**WEST SUSSEX COUNTY COUNCIL
INFRASTRUCTURE CONSULTATION**

SUBJECT: A/24/10 - Outline application for erection of new warehouse

Land North East of Robert House Rudford Industrial Estate Ford

R.T.Page & Sons Ltd
Land at Rudford Industrial Estate, Ford Road, Ford, West Sussex, BN18 0BD:
PROPOSED NEW WAREHOUSE - VEHICLE PARKING and ACCESS - 1/500 scale

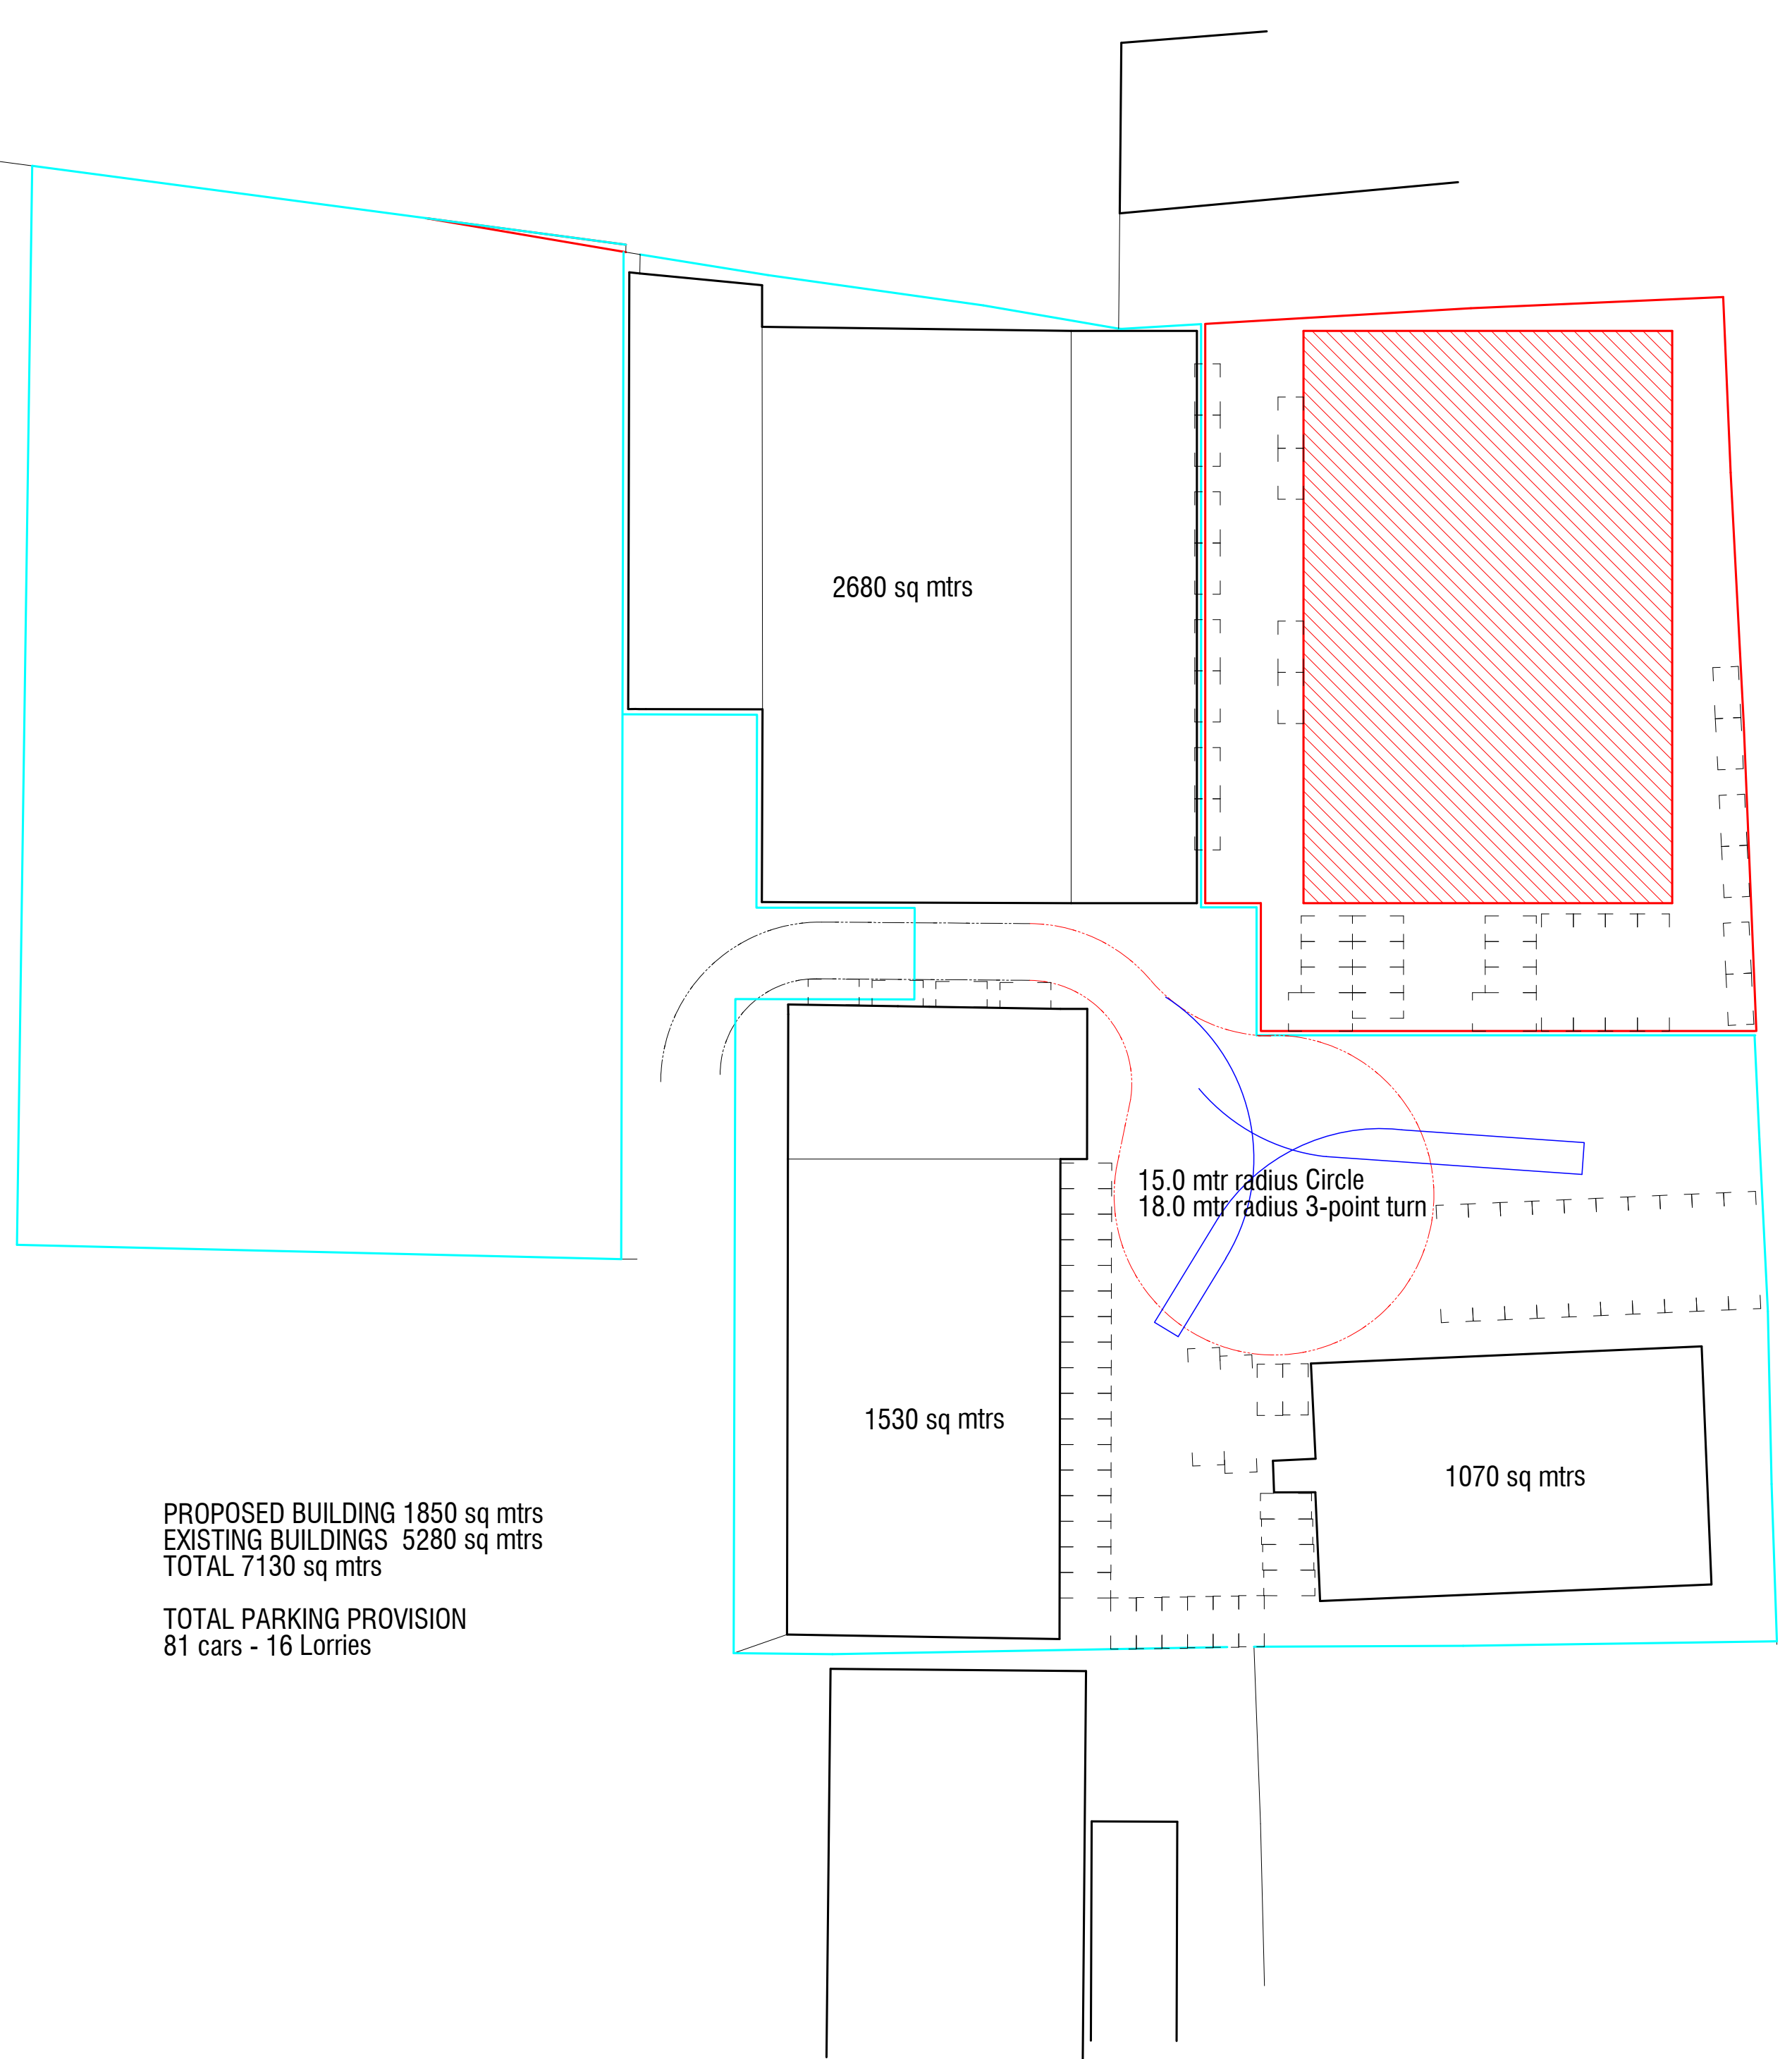
While there is no objection in principle to this outline application, to enable full consideration to be given please could the following be provided:

1. Evidence of the likely daily usage of the site by LGVs and other vehicles
2. Details of proposed conjectural parking and turning arrangements for all vehicles.

These details are requested only to ensure that the site would be able to function safely under its proposed usage and that the likely impact on the local highway network can be accommodated.
